Please ask for: Sian Eggington
Email: sian.eggington@terraquest.co.uk
Telephone: 0121 2341390
Our Ref: AW/35/21/HH
Your Ref:
Date: 24th February 2021

Application for Planning Permission for Works or Extension to a Dwelling

Location: 27 Grosvenor Gardens Aldwick PO21 3EZ

Existing floor plan

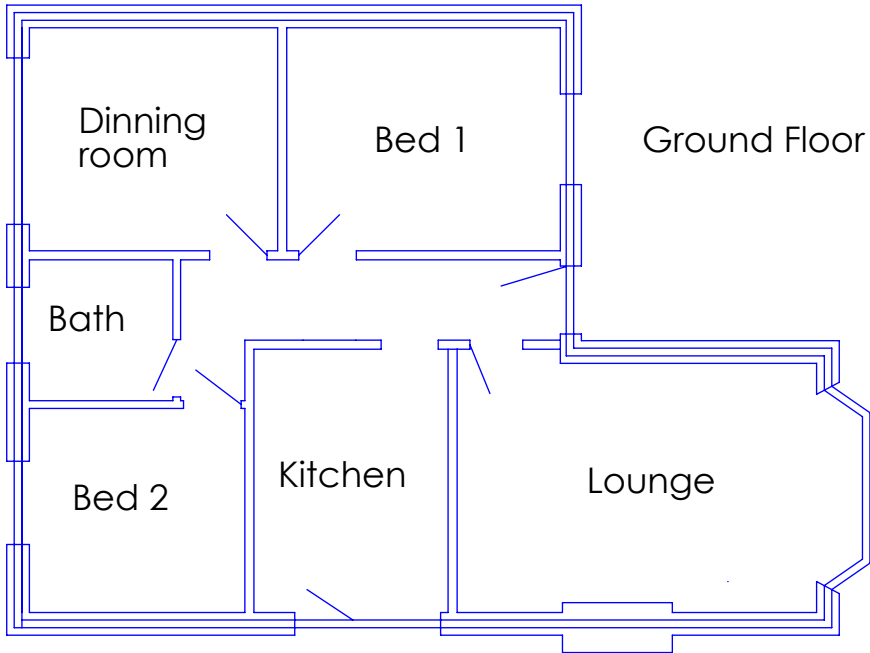
Existing Plans: Please provide the existing plans for this application

Site plan

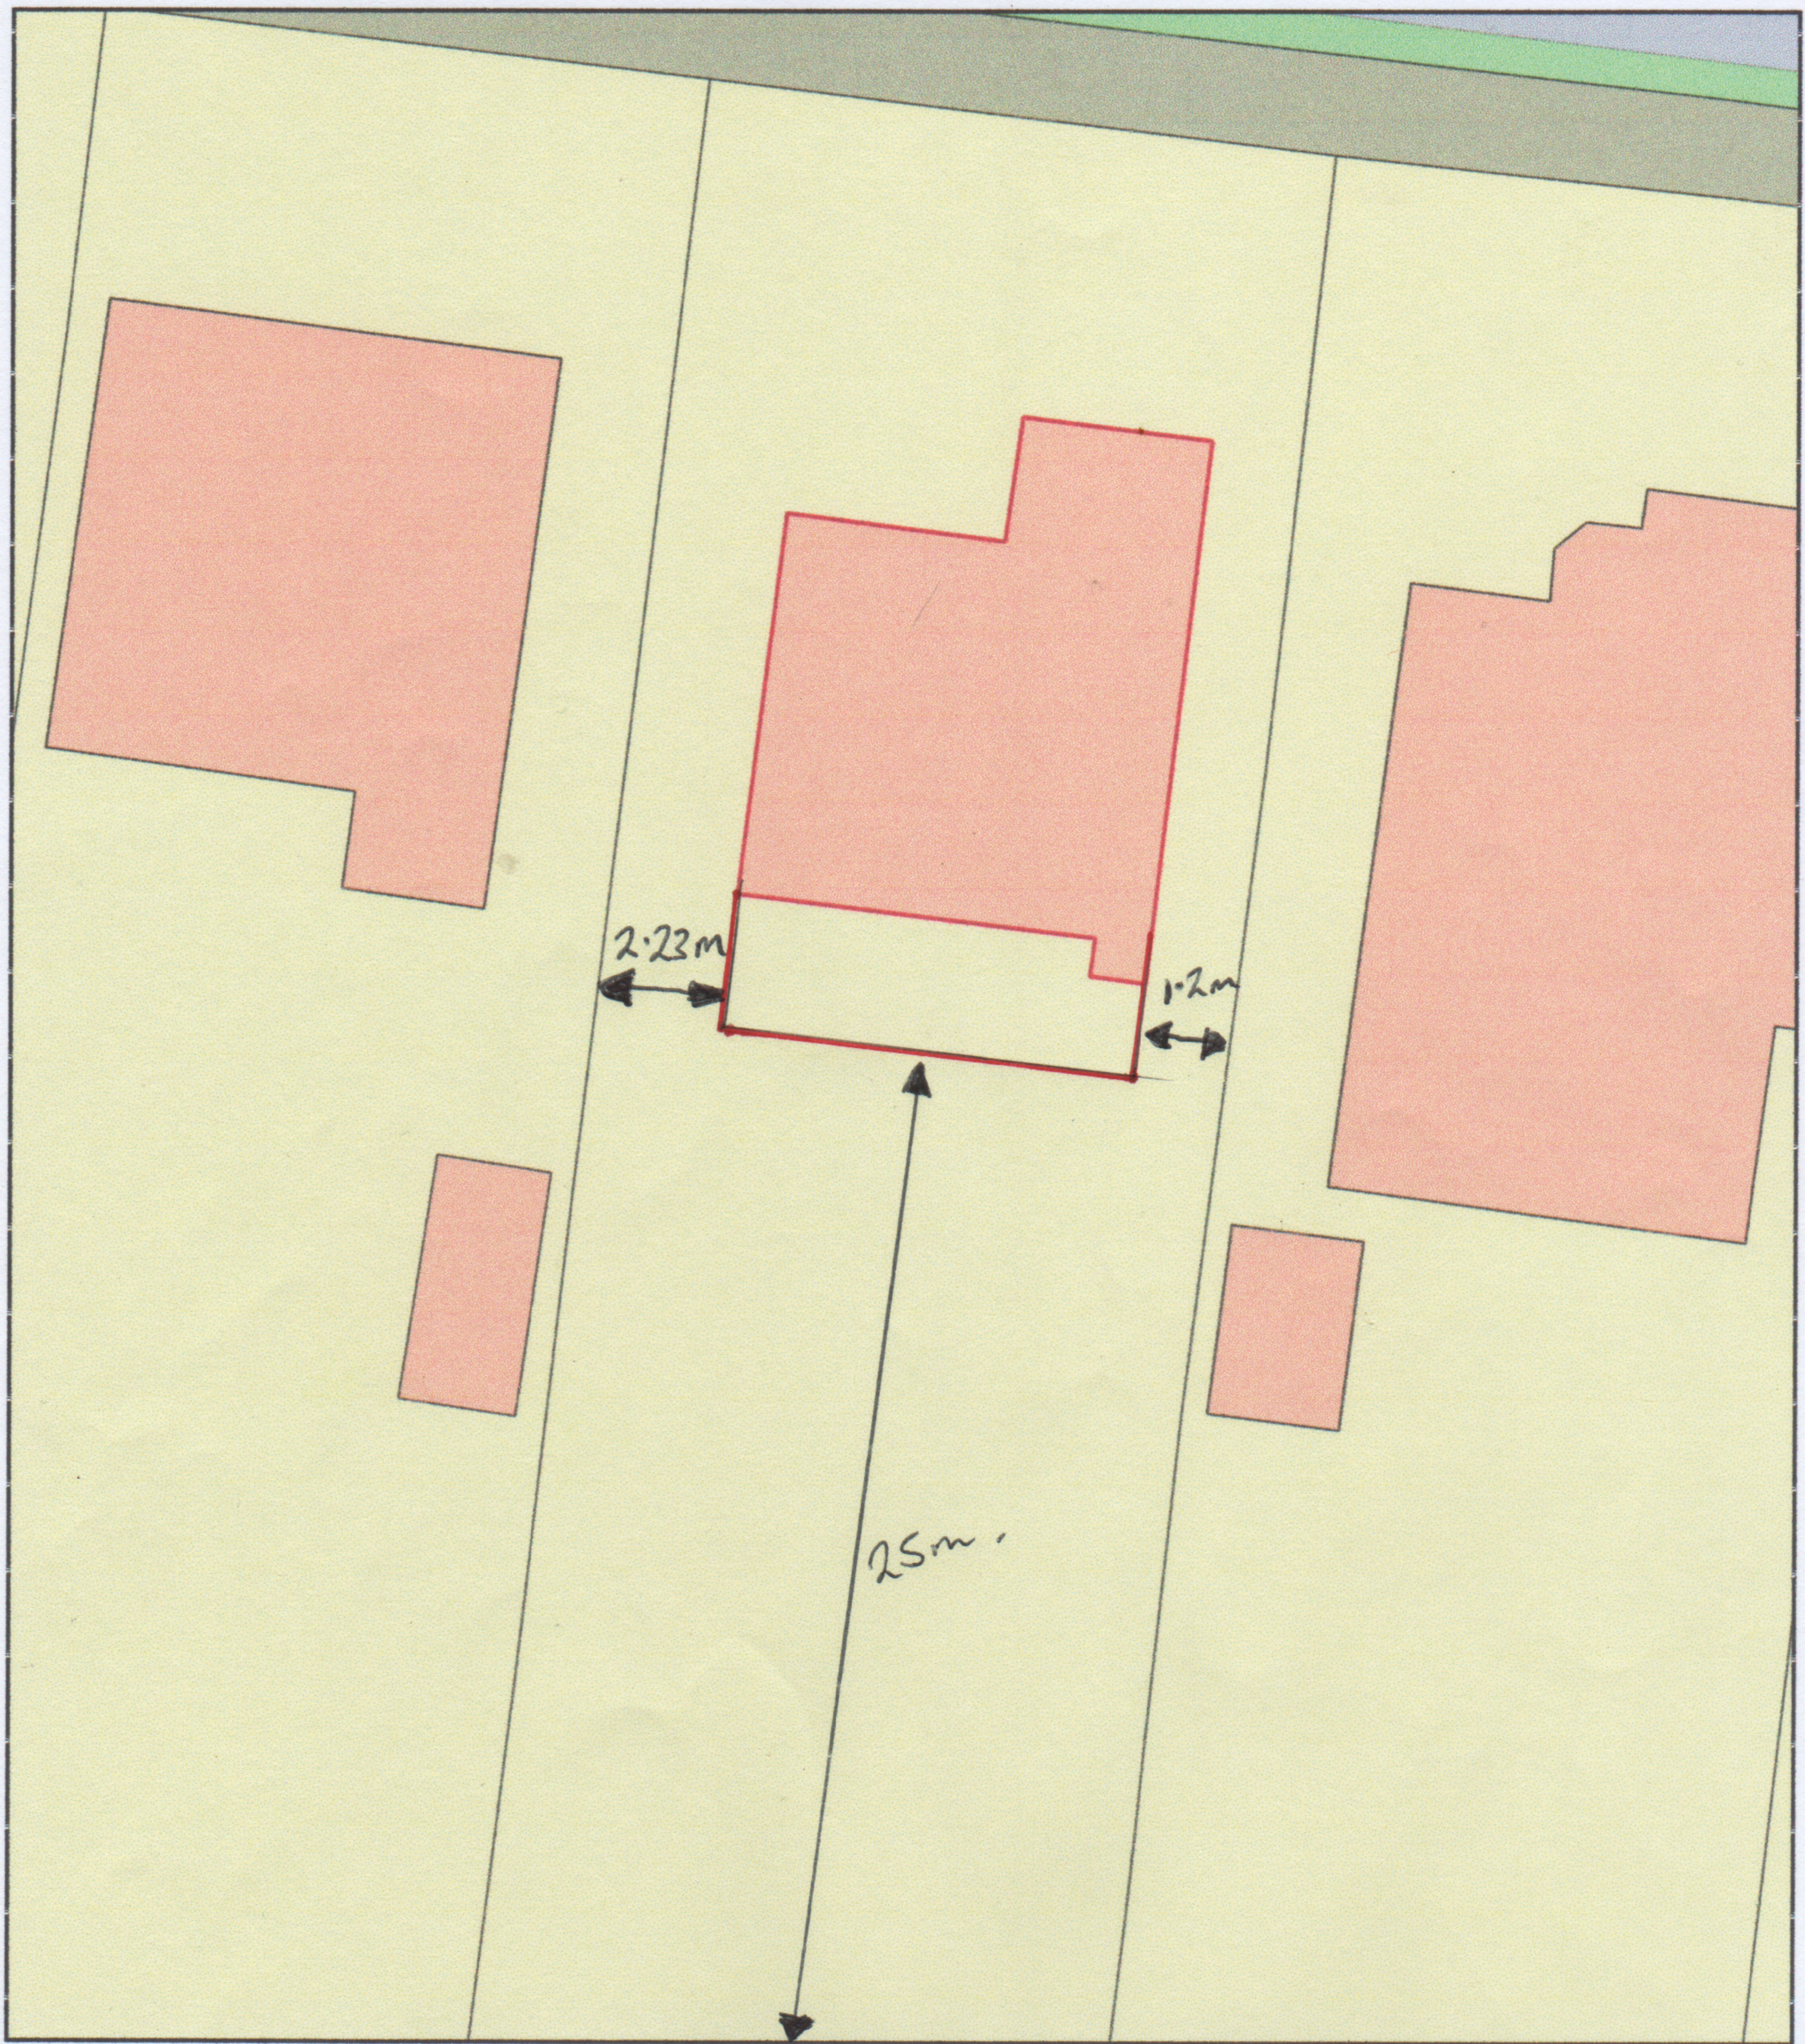
Dimensions: You are required to include dimensions on the block plan from the proposed extension to all site boundaries.
